CITY OF ALBUQUERQUE

August 8, 2013

**Re: West Ridge MH Park
Conditional Letter Of Map Revision (CLOMR)
Engineer's Stamp date (N/A) (K-09/D006)**

Based upon the information provided in your submittal received 06-10-13, we offer the following comments:

ENGINEER'S SEAL RONALD R. BOHANNAN P.E. #7868	WEST RIDGE MOBILE HOME PARK	DRAWN BY DY/BJF
	STORM DRAIN IMPROVEMENTS	DATE 12-07-10
 TERRA WEST, LLC 5571 MIDWAY PARK PLACE NE ALBUQUERQUE, NM 87109 (505)858-3100 terrawestllc.com	SHEET # C4	2731-P&P
	JOB # 27031

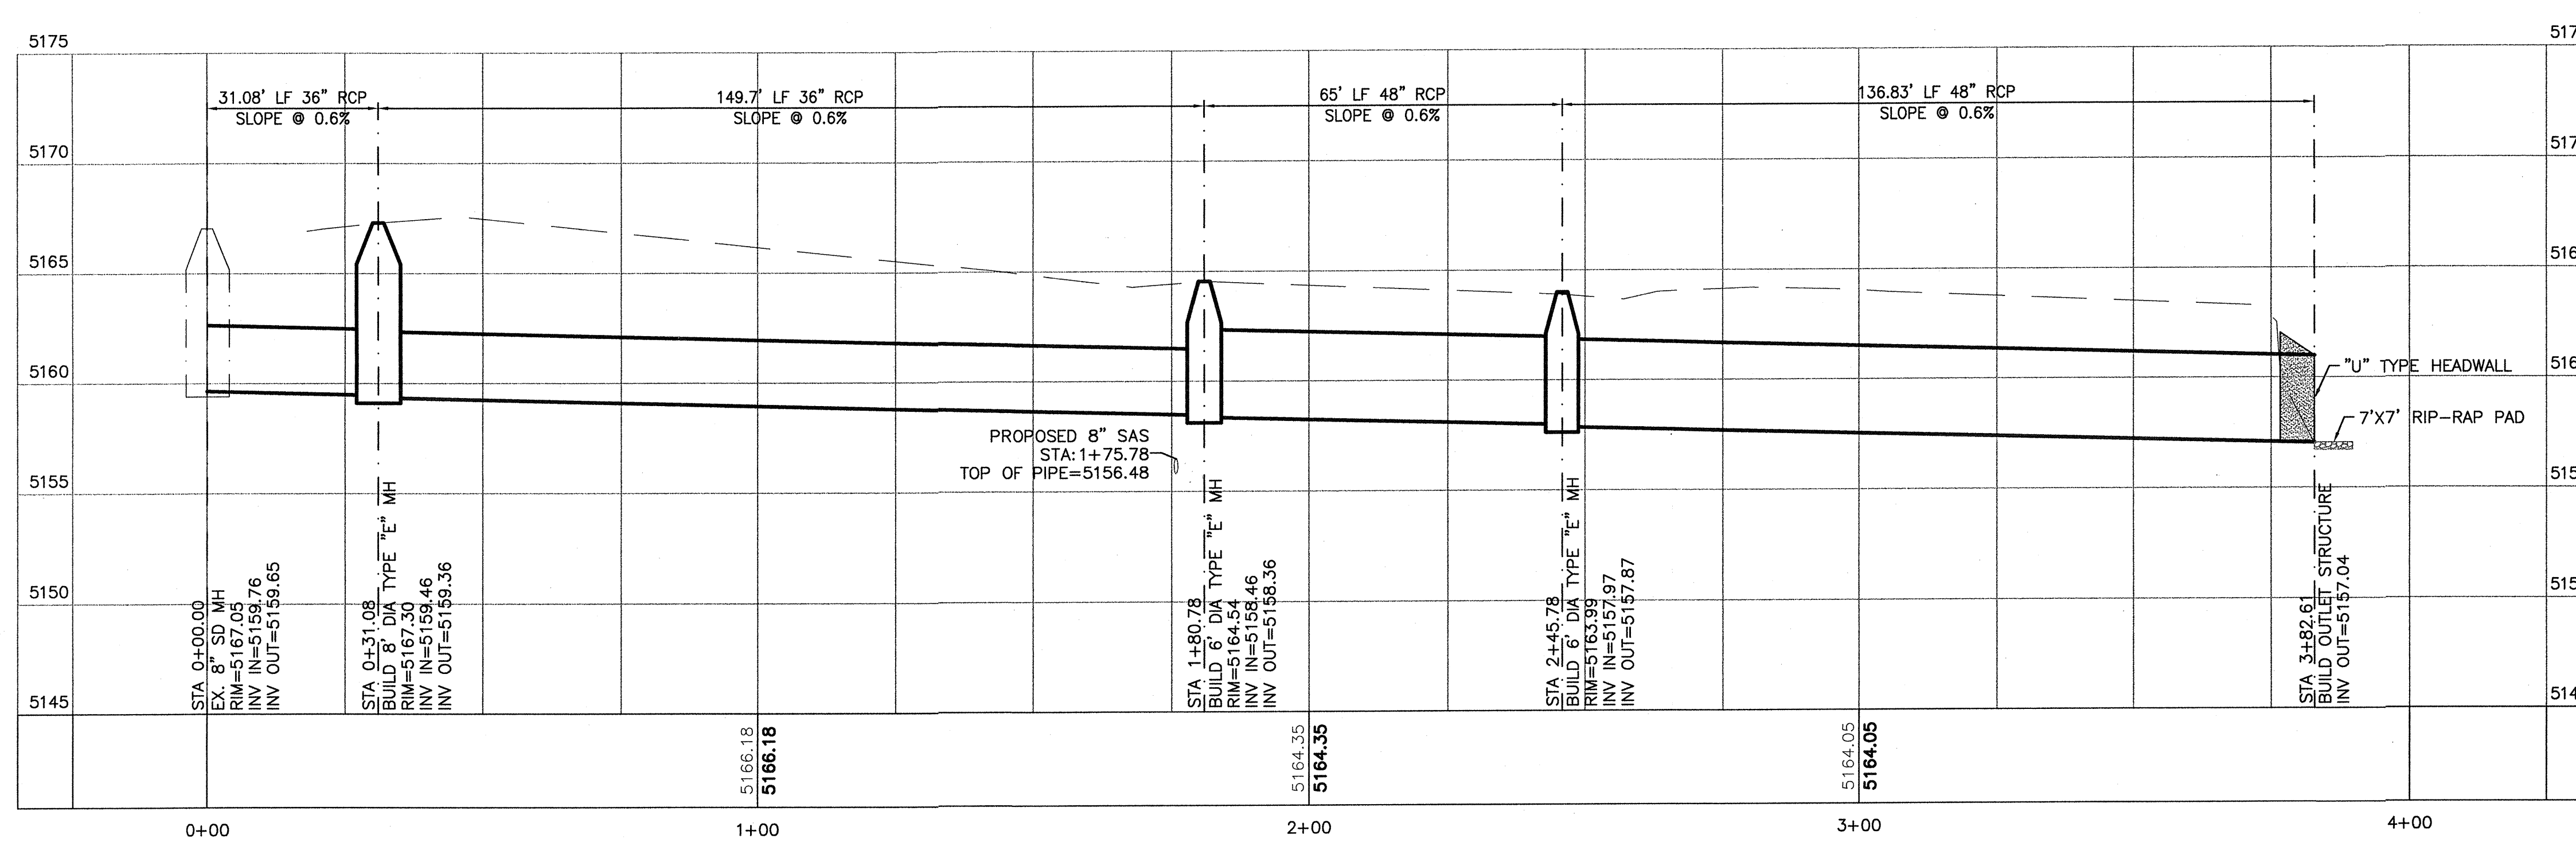
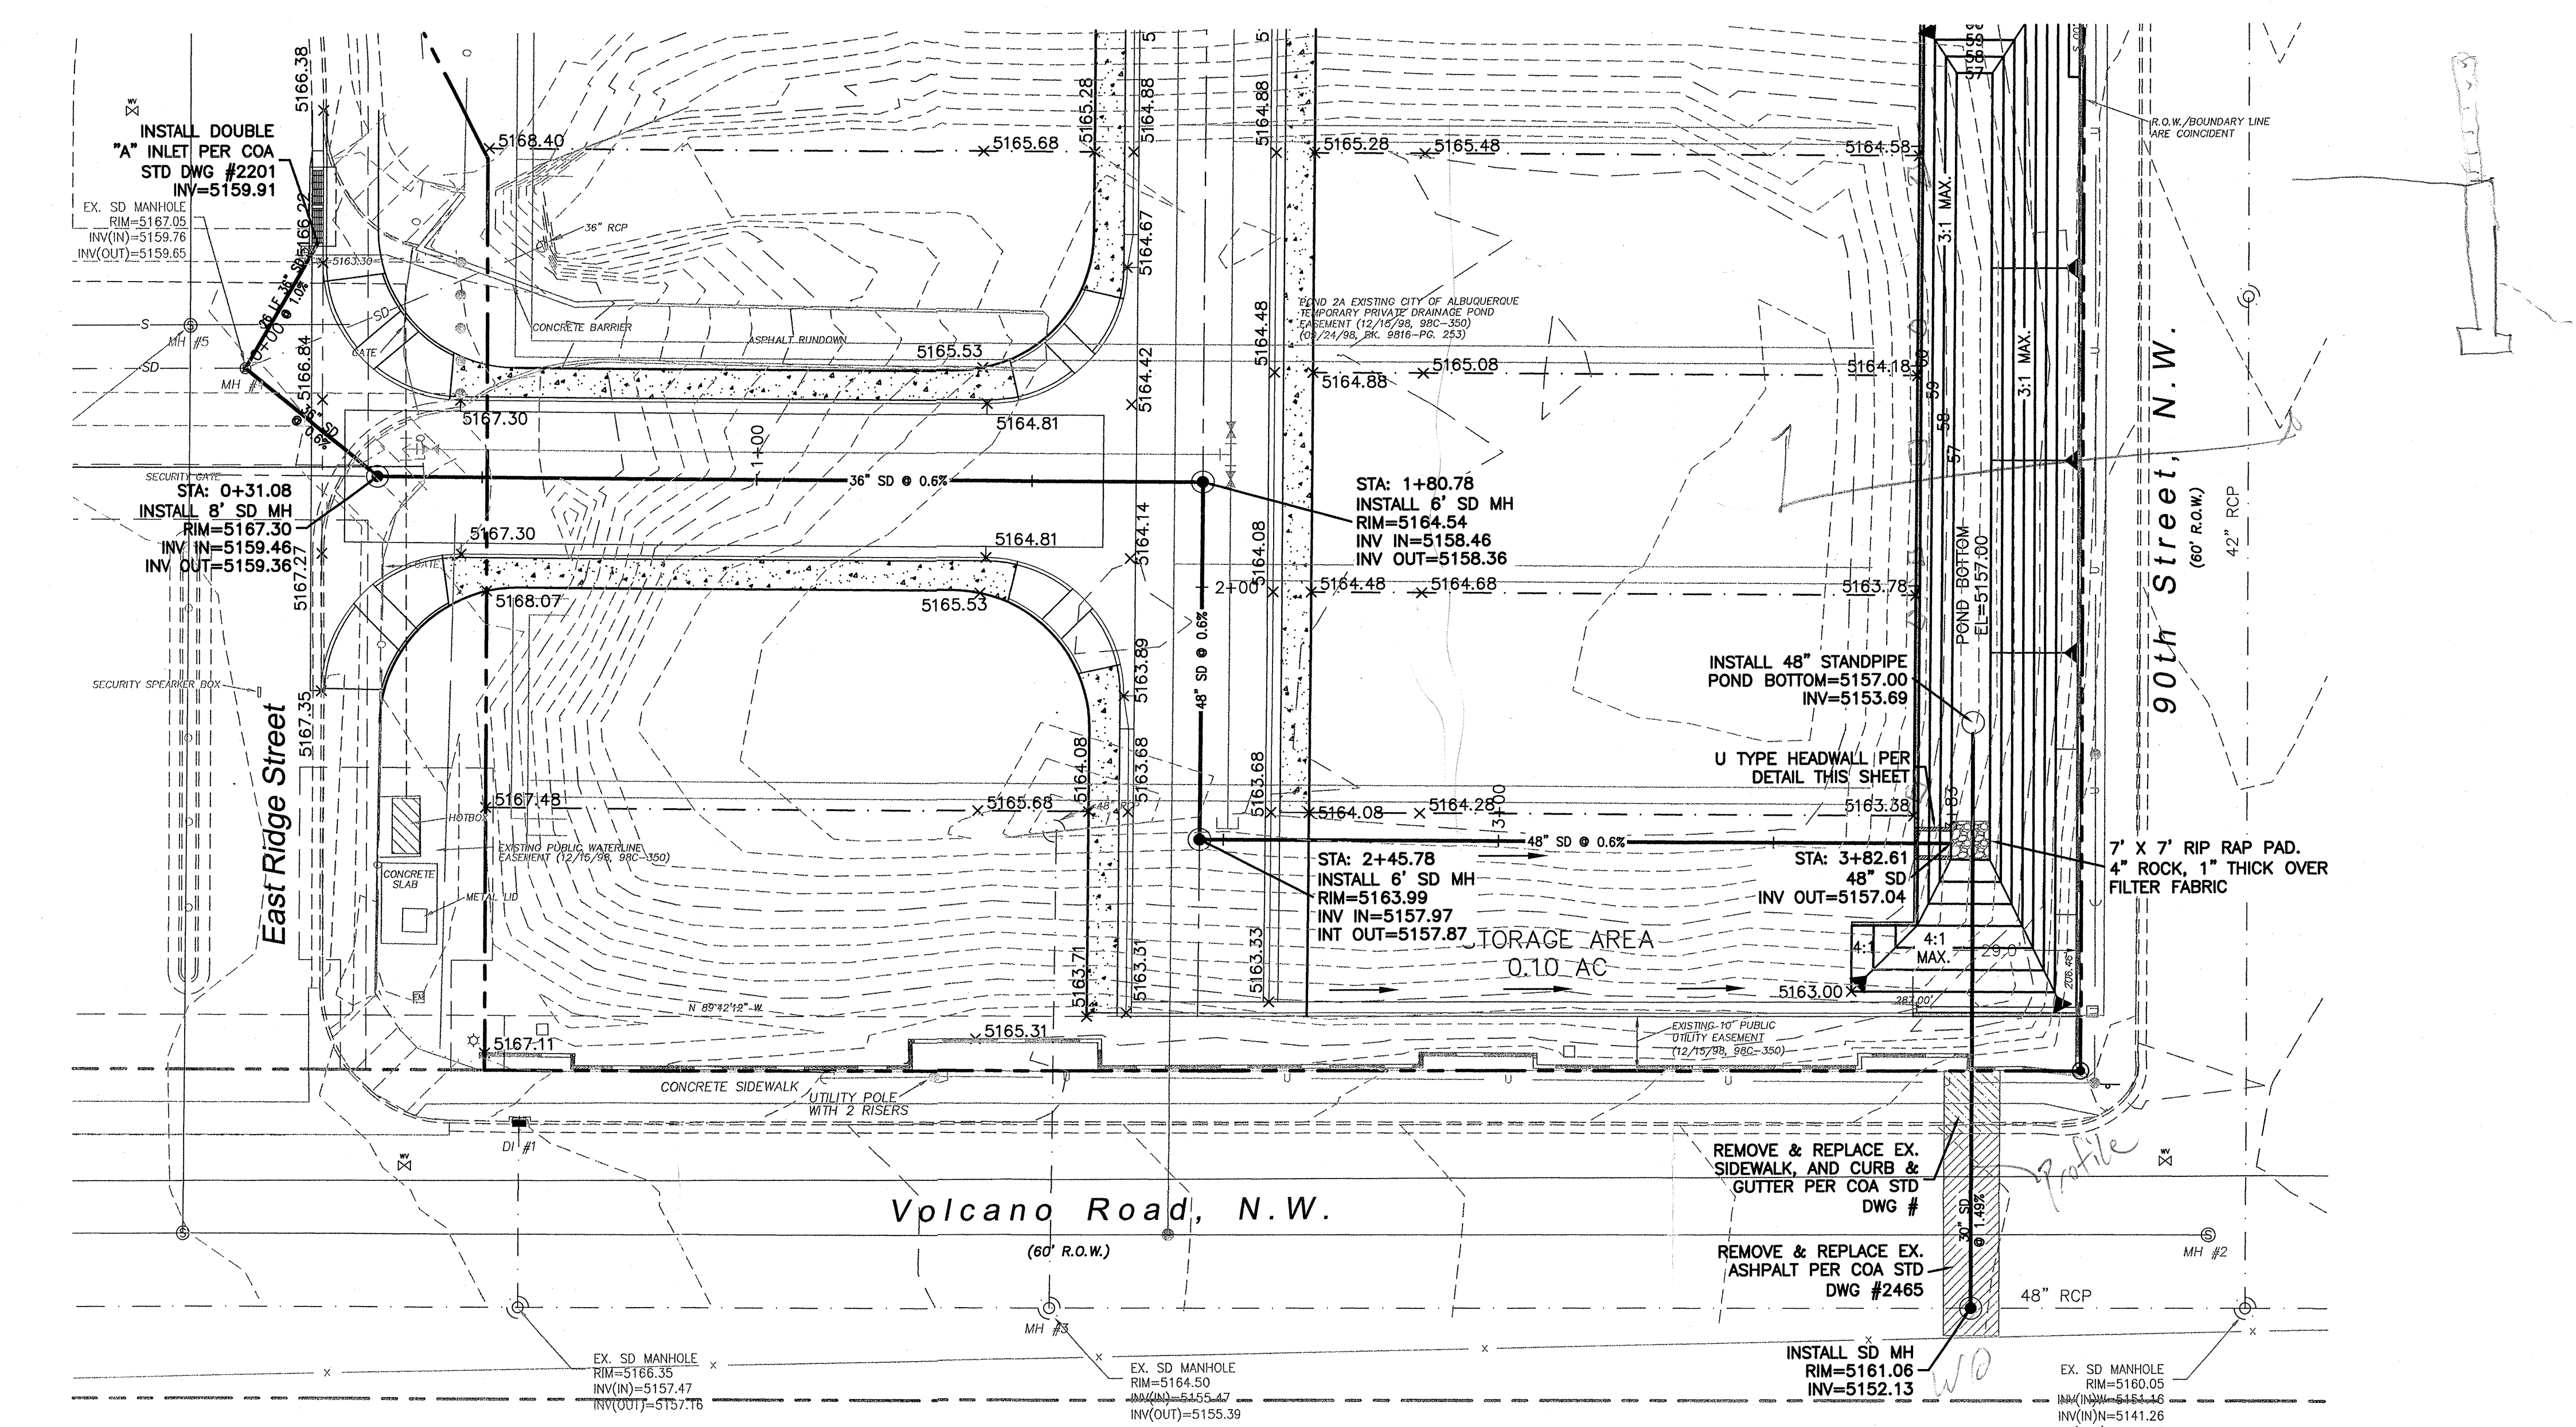
- The following comments are on the previously approved grading plan with engineering stamp date 5/13/2013:
 - a) Please correct the slope of the 30" HDPE pipe and remove additional notes regarding the slope of the pipe. Upstream portion of the pipe is a 36" RCP. We recommend that the HDPE pipe to be revised to 36" HDPE.

STAND PIPE DETAIL
NTS

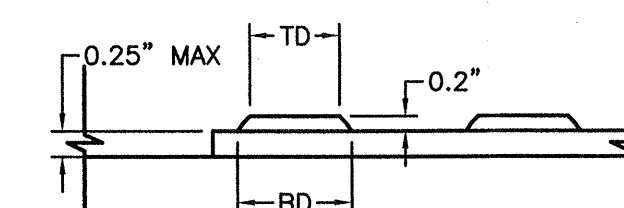
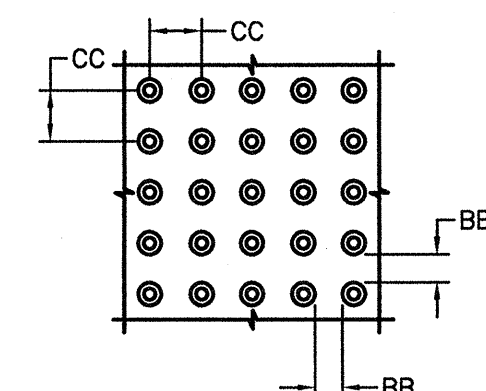
- b) Based on the orifice plate detail provided the invert of the 48" pipe and orifice plate is different. Please include the invert for the orifice plate. Which invert was used to calculate the discharge rate for the AHYMO runs? Please change the note on the plans from 28" to 27.75" diameter orifice plate.
